**SSD 6626 - SICEEP Darling Square - Mixed Use Residential  
Building within North-East Plot**

## SSD 6626 Submission

Concept proposal
parameter plan shadows
for N + SE plots

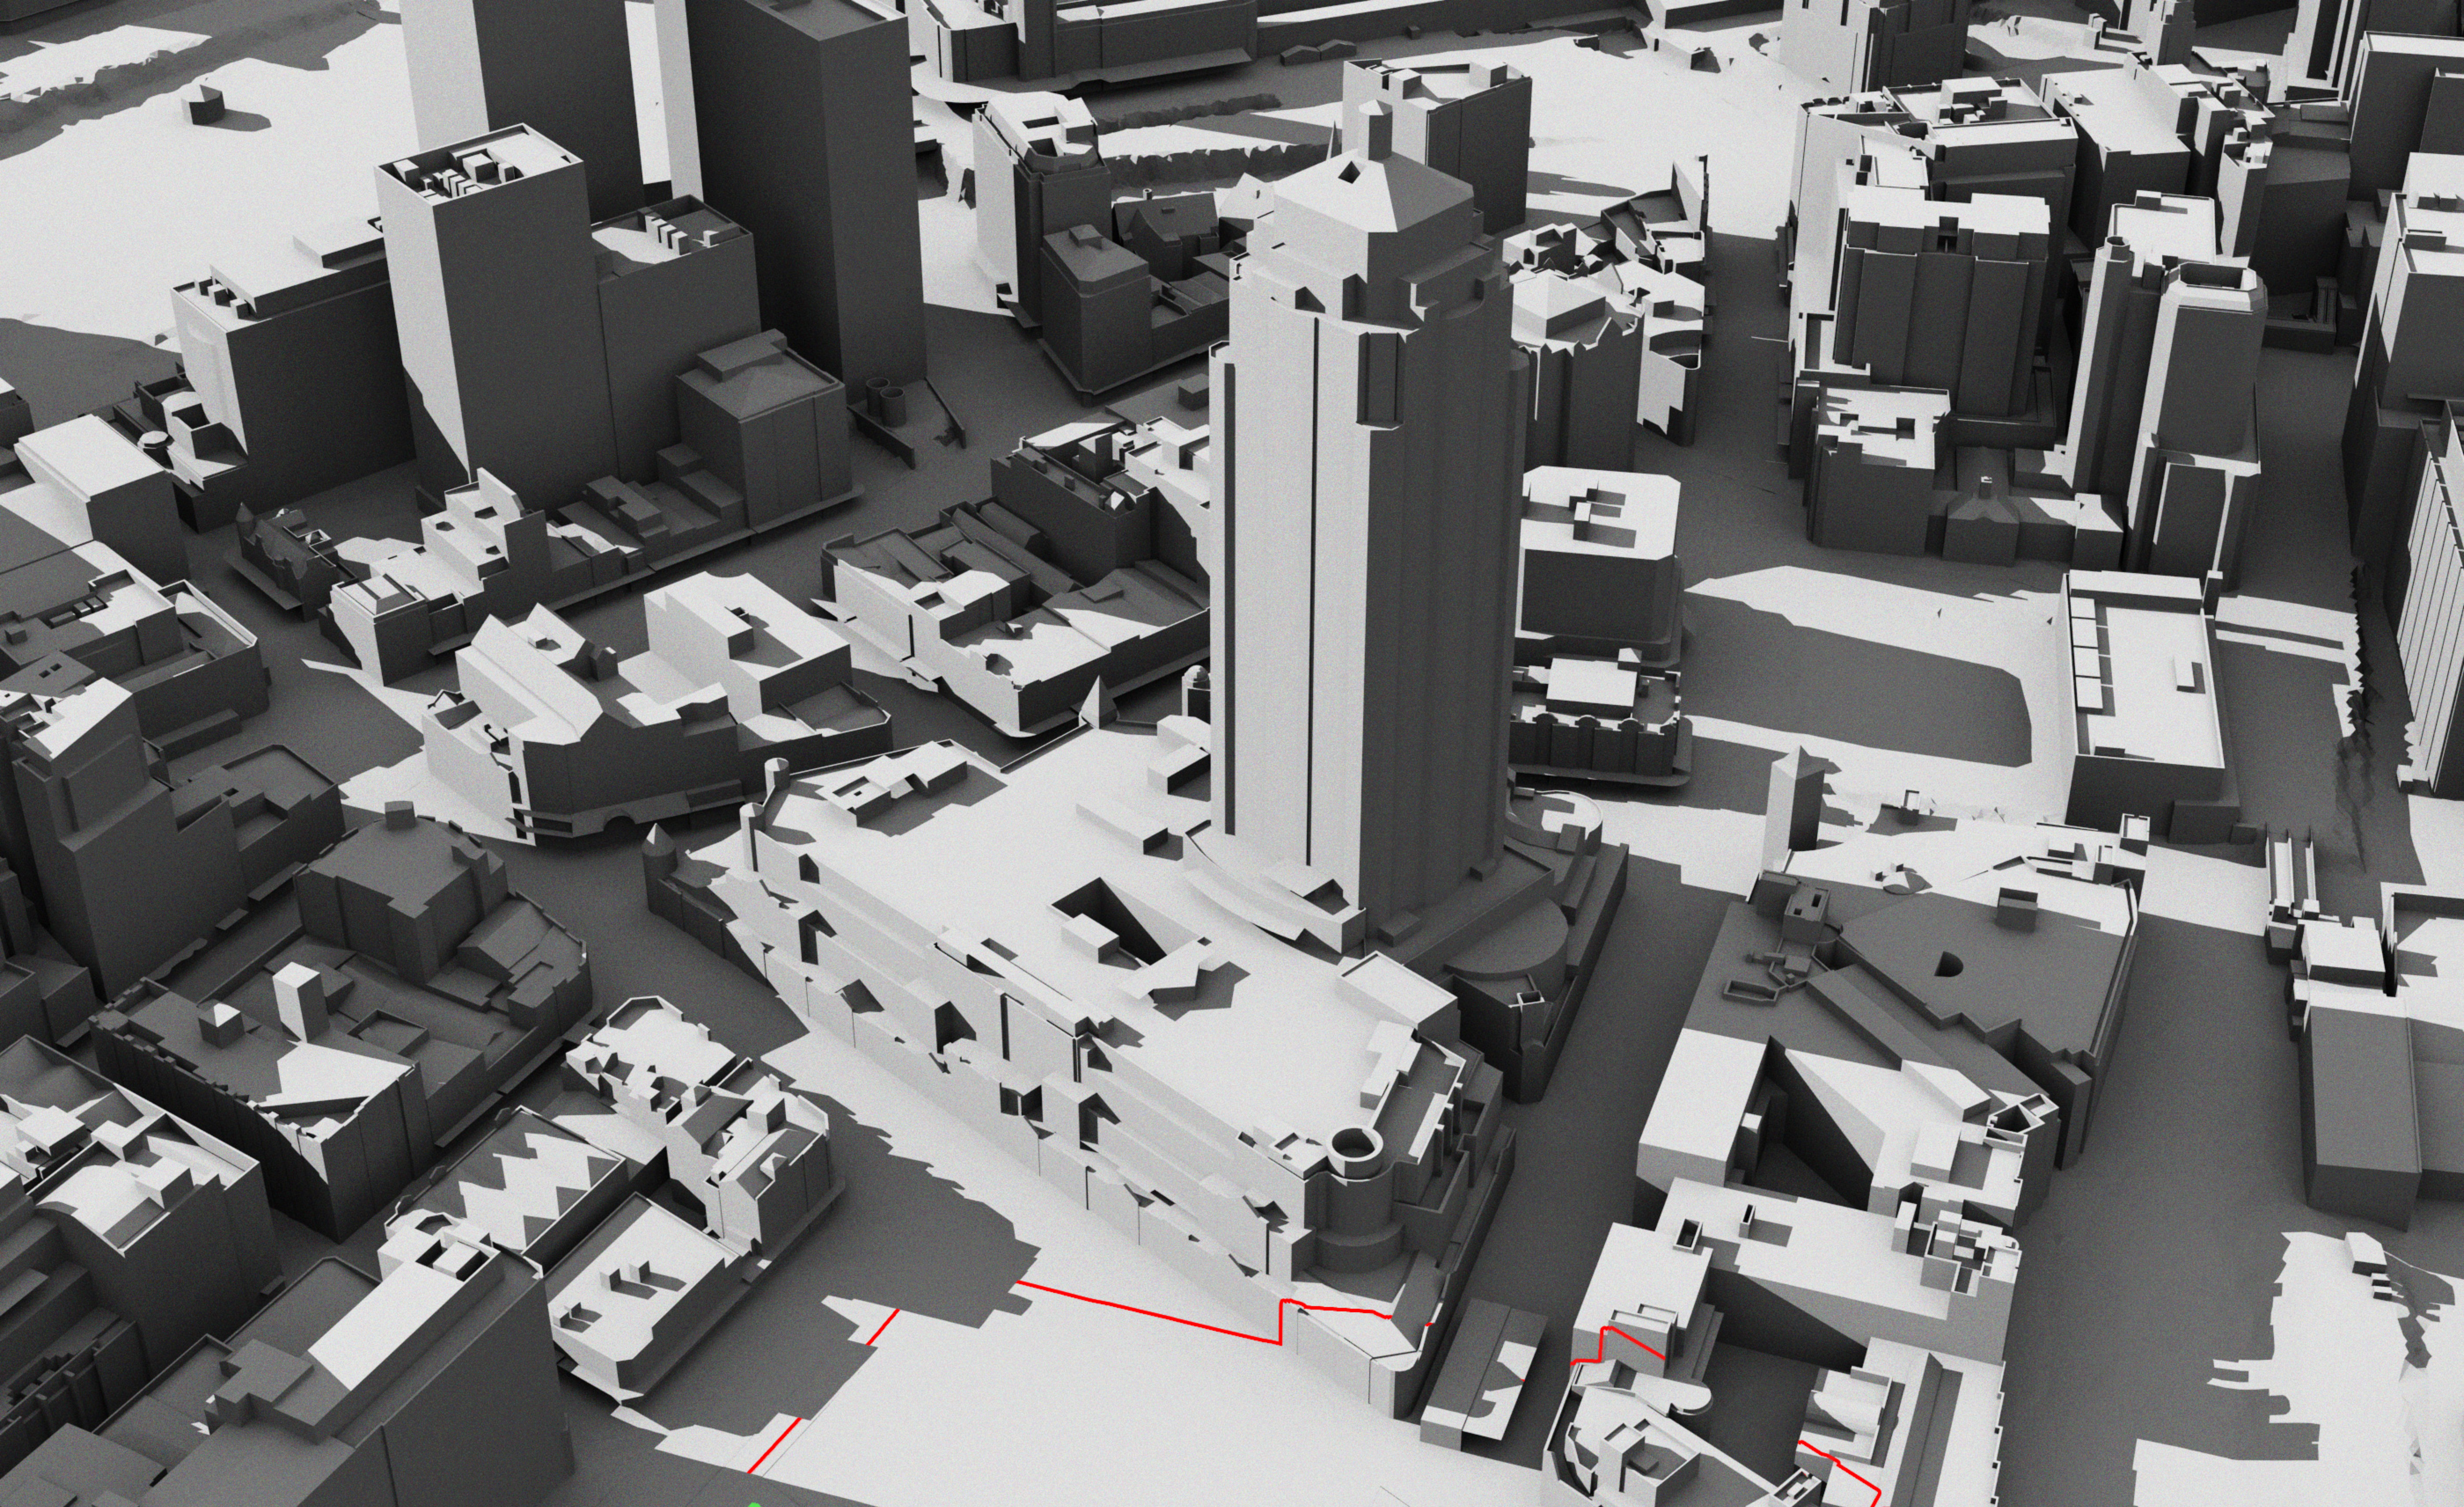
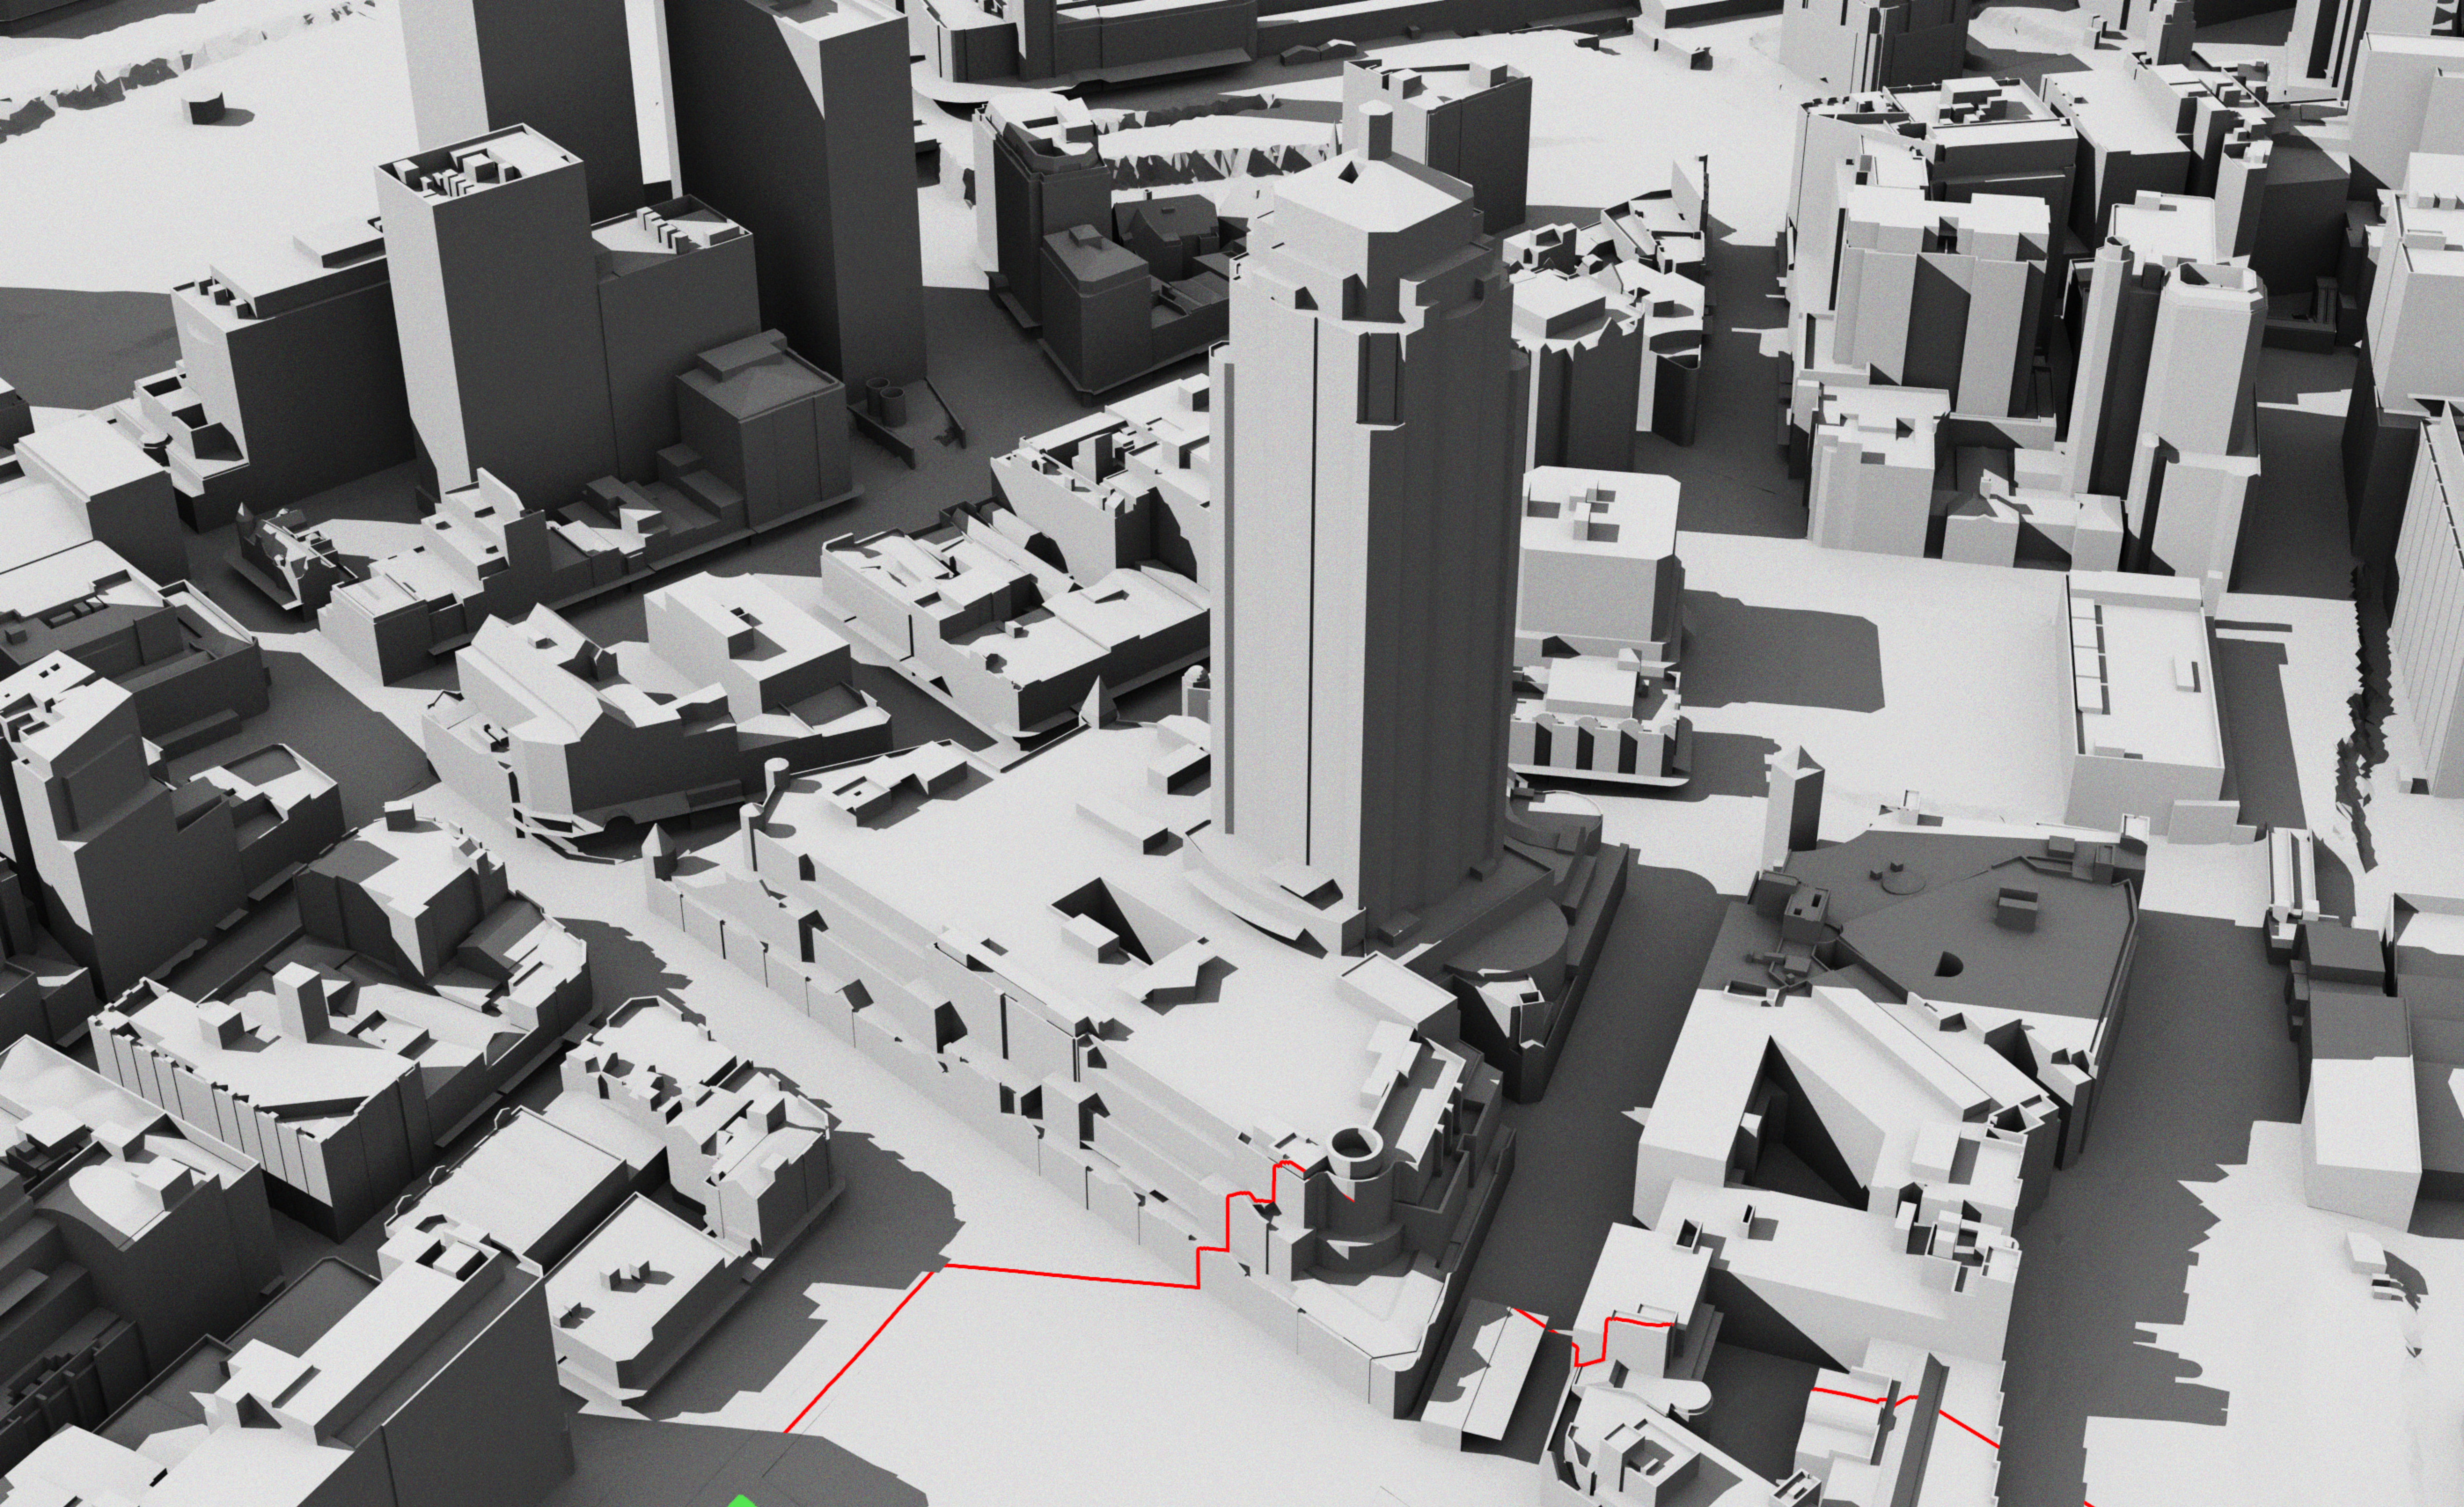
With respect to the podium of The Peak Apartments, the EIS states that "The landscaped podium associated with The Peak Apartments will continue to receive at least two hours of solar access, ensuring compliance with the intent of the Sydney DCP 2012.". Although this statement is true, two hours is a major reduction from the existing 21 June daylight access of about six hours.

There is no overshadowing of apartments in The Peak by the NE plot. The overshadowing is by the SW plot being developed by the same proponent.

We take this opportunity to reiterate our submission on SSD 6011 (SW Plot) which stated "It can be concluded that, as a result of combination of the proposed (SW) development with existing shadowing of the west façade, some single aspect apartments on the west façade and the south-west dual aspect corner apartments which currently receive less than 2 hours direct sunlight to habitable rooms and 50% of the private open space between 9am and 3pm on 21 June will suffer additional overshadowing. " At the time of designing the development, the proponent was, despite having made numerous site visits, unaware that there were single aspect apartments in the Peak. The proponent now belatedly accepts that there are 110 apartments in the Peak which are single aspect west or north. The proponent's response to not meeting DCP overshadowing standards for those apartments was "The Sydney DCP does not apply to the SICEEP site." (SSD6011 South West Plot SSDA5, Response to Public Submissions, p2). Presumably the proponent will make the same response on any point where its standards fall below those of the Sydney DCP. And the consent authority is apparently not concerned by adopting standards below those of the Sydney DCP.

We agree with the City of Sydney's view that "excessive morning shadows are cast into the outdoor and café areas in the new square by new surrounding building edges. In order to improve morning sun access to the square in winter, it is recommended that the building heights lining the new square be reduced and the floor area relocated to the surrounding streets podium edges..." Source: City of Sydney, SSD 5878 (SICEEP) The Haymarket submission, page 34.
